30 Merrill Project

Helen Donaldson <hcd@portlandmaine.gov>
To: Eric Wittman <eric@bildarchitecture.com>
Cc: Evan Carroll | Bild Architecture <evan@bildarchitecture.com>

Tue, Sep 13, 2016 at 1:43 PM

12 FENCE DETAIL  
SCALE: 3/4" = 1'-0"

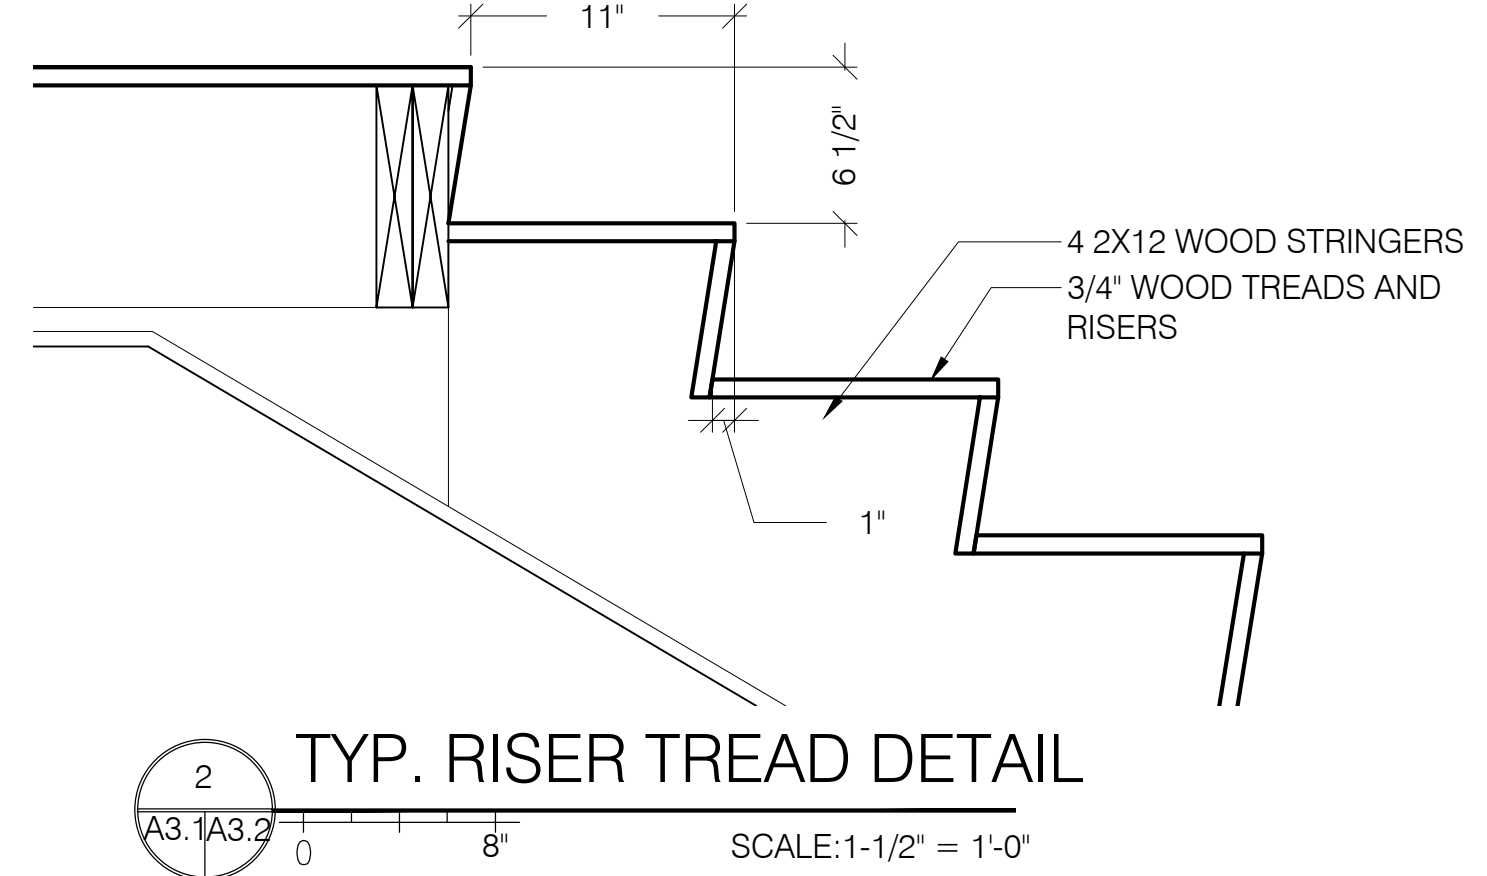
- The site layout plan, if it is to stand in for a landscape plan, should include a table identifying plant types, quantities, and sizes.
- We need to review a fence detail.
